DEVIATION REVIEW AND DECISION FORM

Deviation No. 2
REV. 2-8-19

Subdivision or Project Name: Rollin' Ridge Estates

Specific Criteria from Which a Deviation is Sought: Table 2-5 - Intersection spacing along a Rural Minor Arterial.

Deviation Exhibit

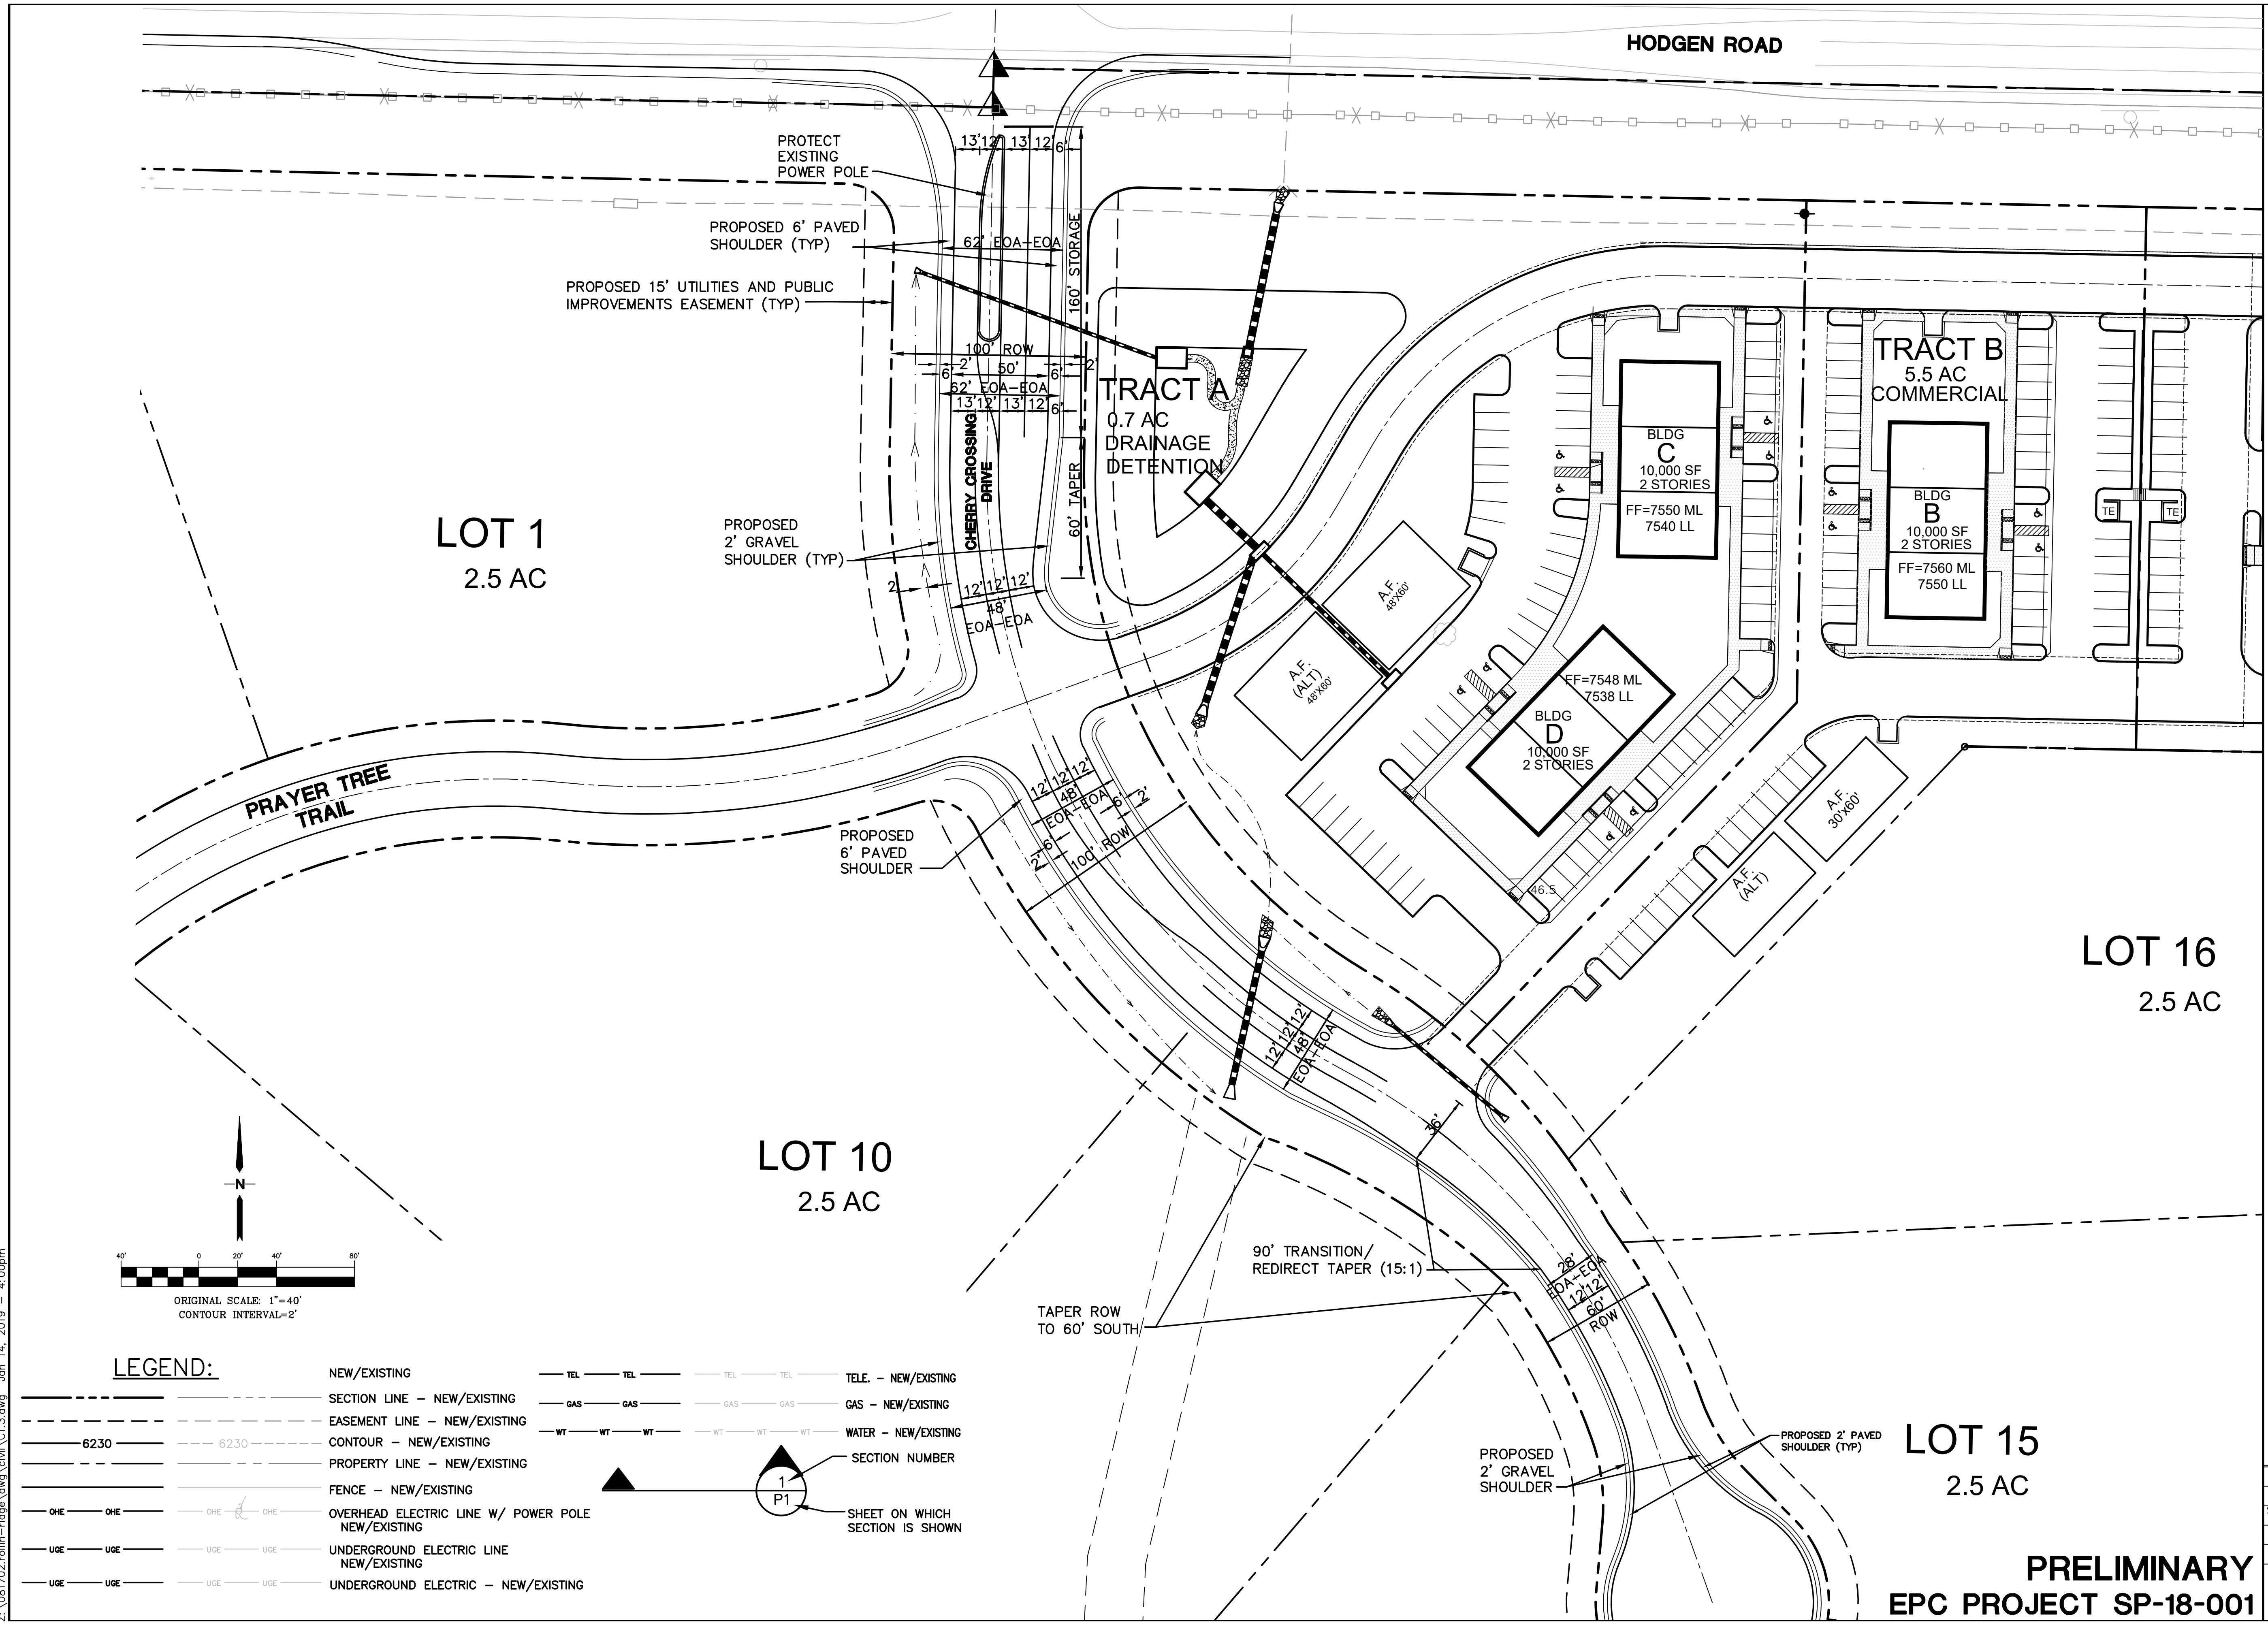
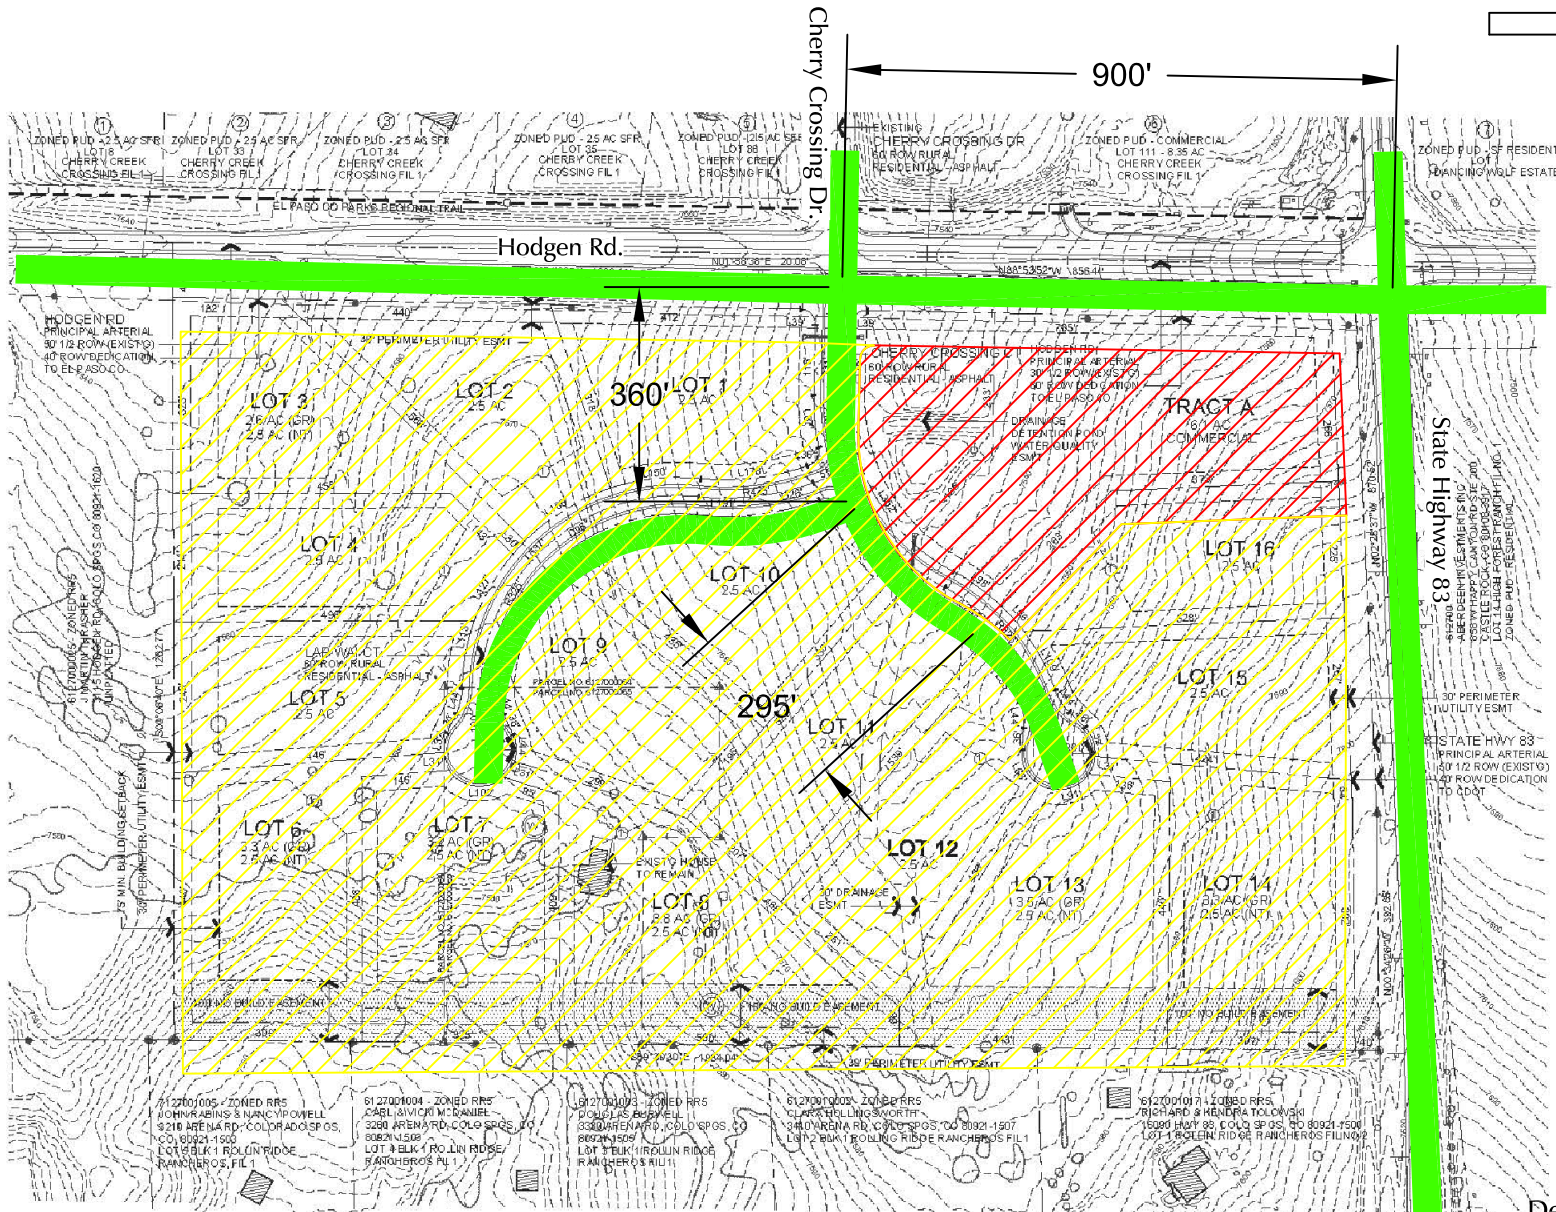
This deviation and deviation 1 have the same request, intersection spacing on Cherry Crossing between Hodgen and Prayer Tree Trail. Please remove the intersection spacing request from deviation 1 (ie, do not ask twice). Please clean up all exhibits (for ALL deviations), removing all unnecessary exhibits for the given deviation and marking/highlighting the area of concern consistent with the request for each specific deviation. Private driveways for commercial sites have different requirements, per road classification, than street intersections. Please adjust your deviation request to state that you are adding the two commercial accesses where none are allowed per table 2-4 of the ECM (not that your spacing is not to ECM standards). A deviation for the spacing of the intersections (Hodgen and Prayer Tree Trail) is also required.

In general, this deviation request is for intersection spacing but you reference the 'commercial access'. It should reference an intersection (not a commercial access) when requesting a deviation for "INTERSECTION" spacing. Again, this deviation should request two things, intersection spacing and the addition of two commercial accesses onto a Minor Arterial.
